Subject: Munjoy Heights - Redfern Properties, LLC – Portland
Re: Ability to Serve

Subject: Munjoy Heights - Redfern Properties, LLC – Portland
 Re: Revised Ability to serve with PWD water

Attn: William H. Savage, P.E.
Re: Munjoy Heights; Sheridan Street, Portland
Ability to Serve with PWD Water

DRAWING NO. **C-10**

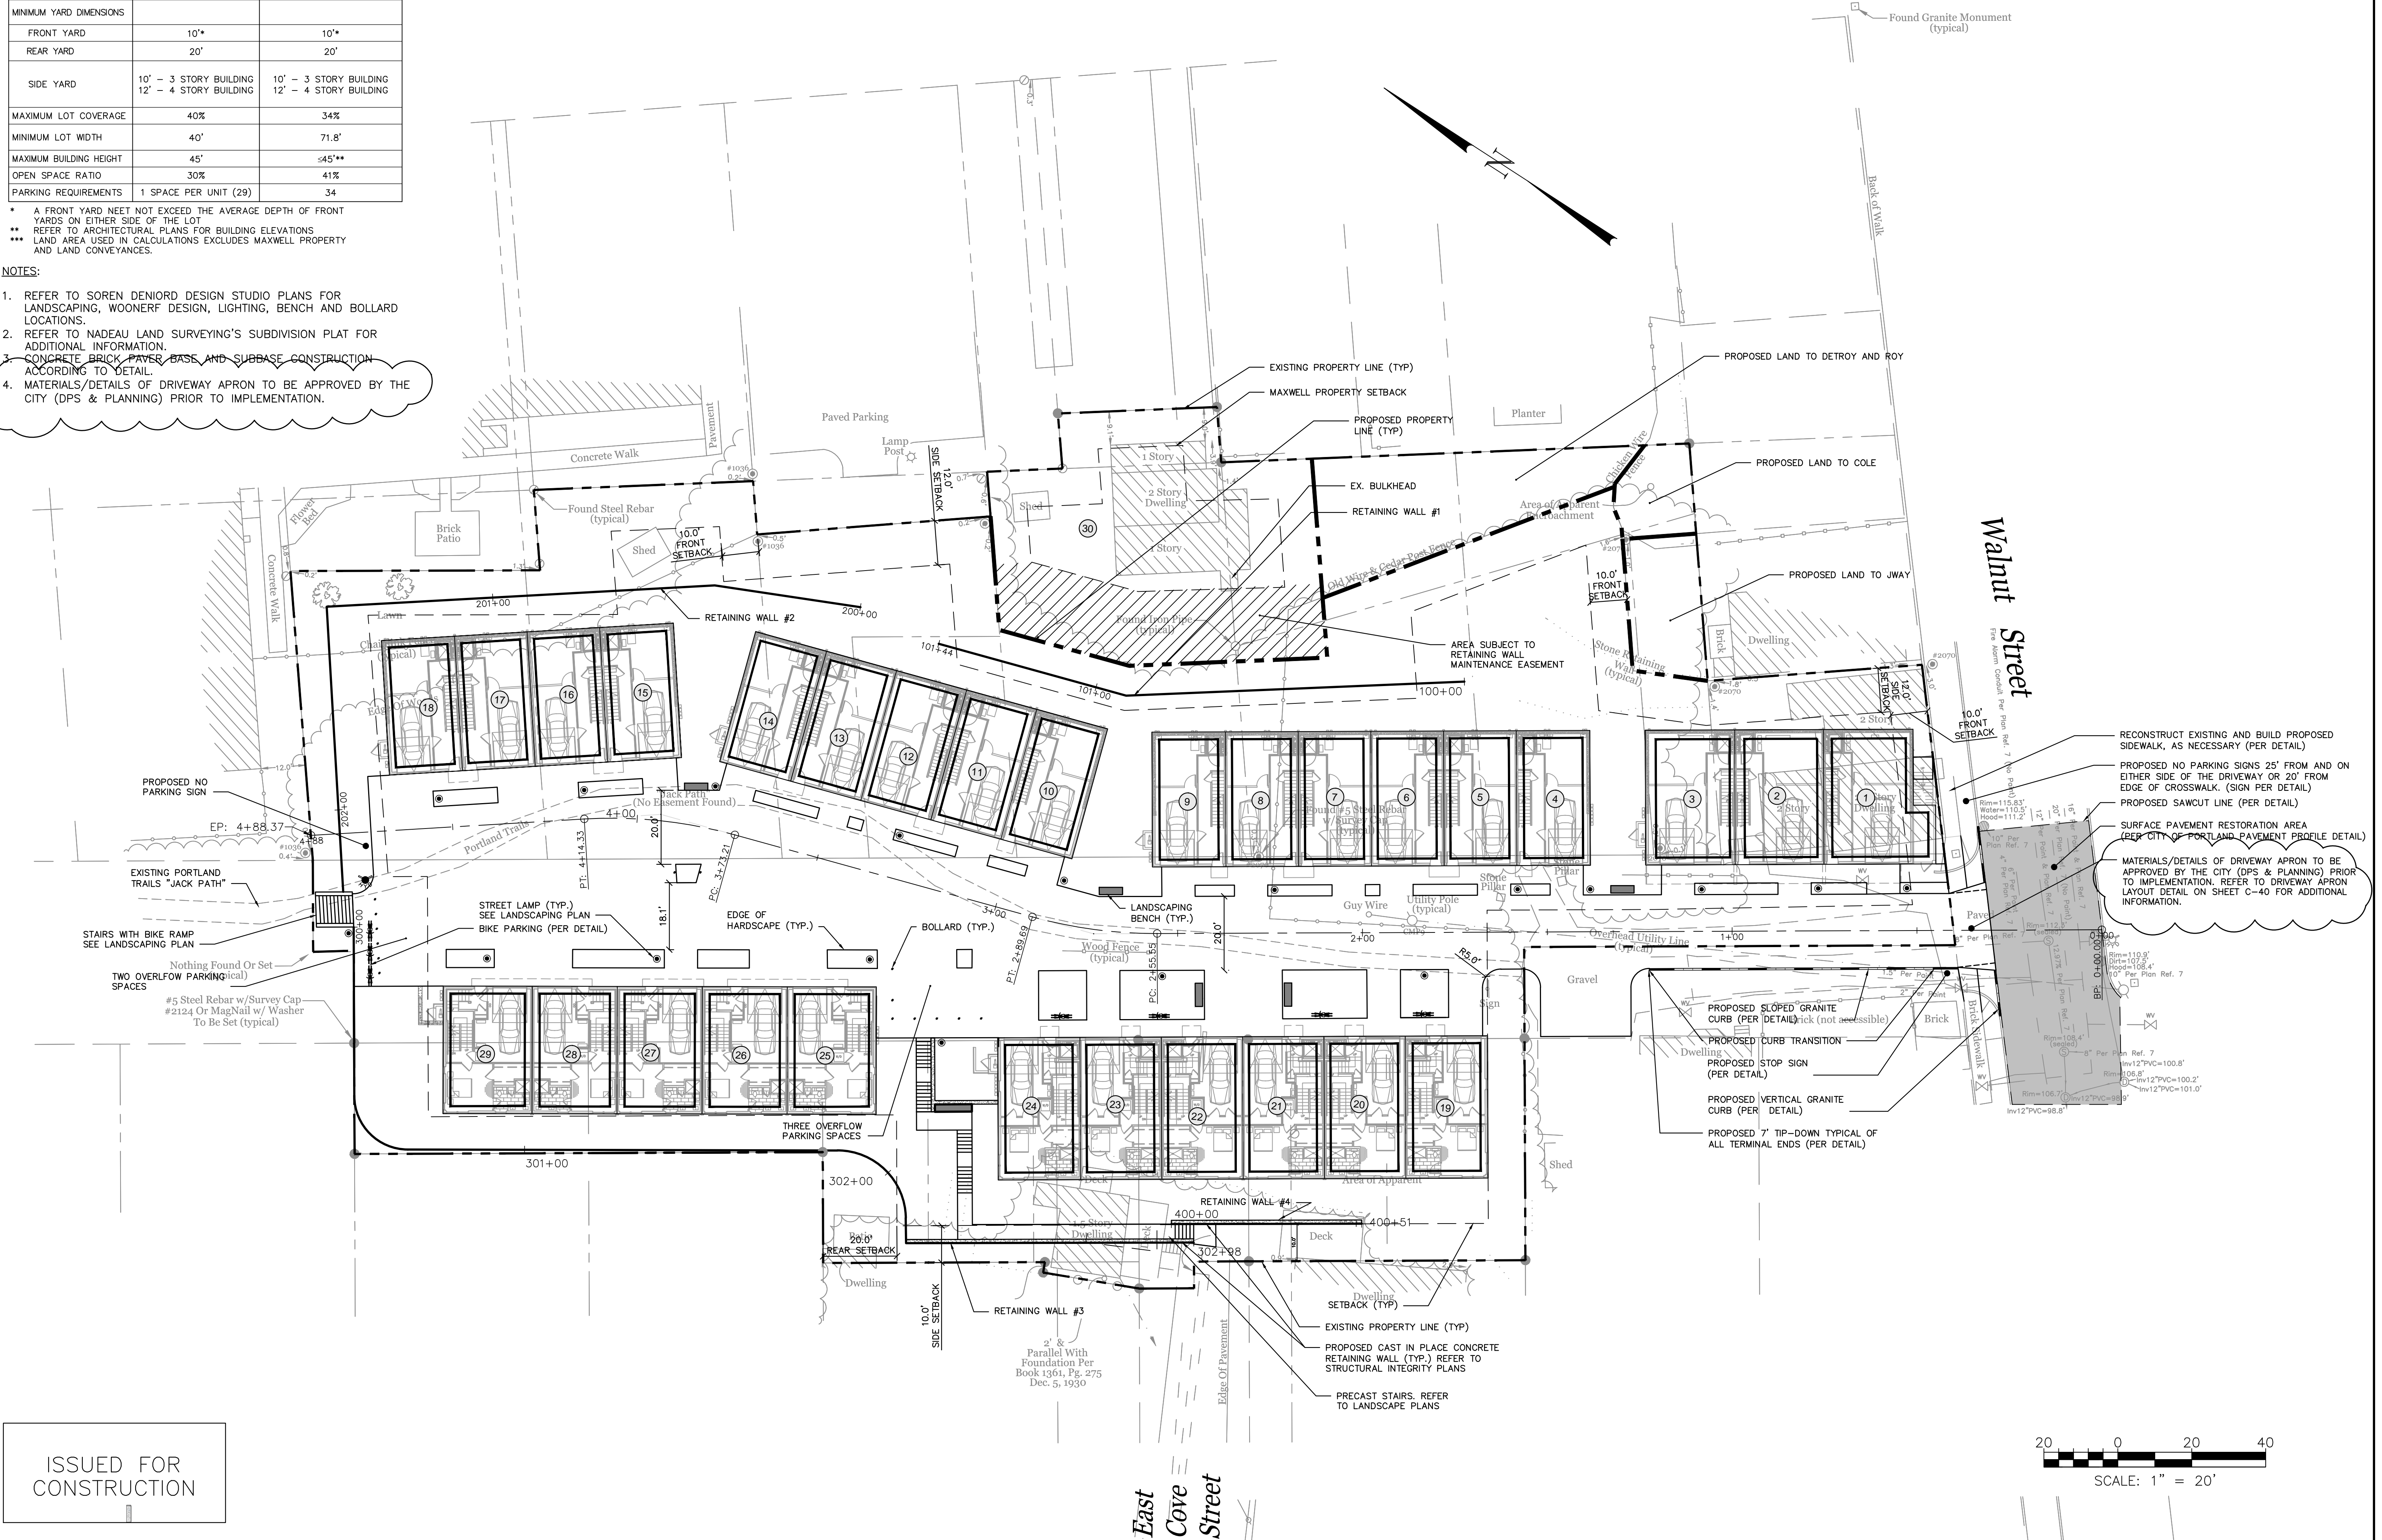
We have reviewed the Utility Plan dated August 16, 2013 for the Munjoy Heights project. Since each of the 29 units is located within a single parcel, the District would prefer not to own and maintain a water main through the private development. We suggest a water service configuration consisting of either separate fire and domestic services or a single combined fire and domestic service with a fire line meter. Either of these scenarios would only have one meter (likely in a pit) and one District account. The condo/homeowner association may choose to install private meters for each unit or split the bill proportionately.

The above configuration would still require an 8-inch main extension of approximately 150-feet from Walnut Street to the edge of the property line. Any existing services that are connected to the 2-inch galvanized water main should be tied over to the new 8-inch main. The 2-inch galvanized main must be terminated. The existing dwelling at 128 North Street Rear may continue to be served by the existing water service connection to North Street.

The District does not currently have an easement for the galvanized water main in the vacated paper street. Easements will be required from the abutting properties for the new main extension.
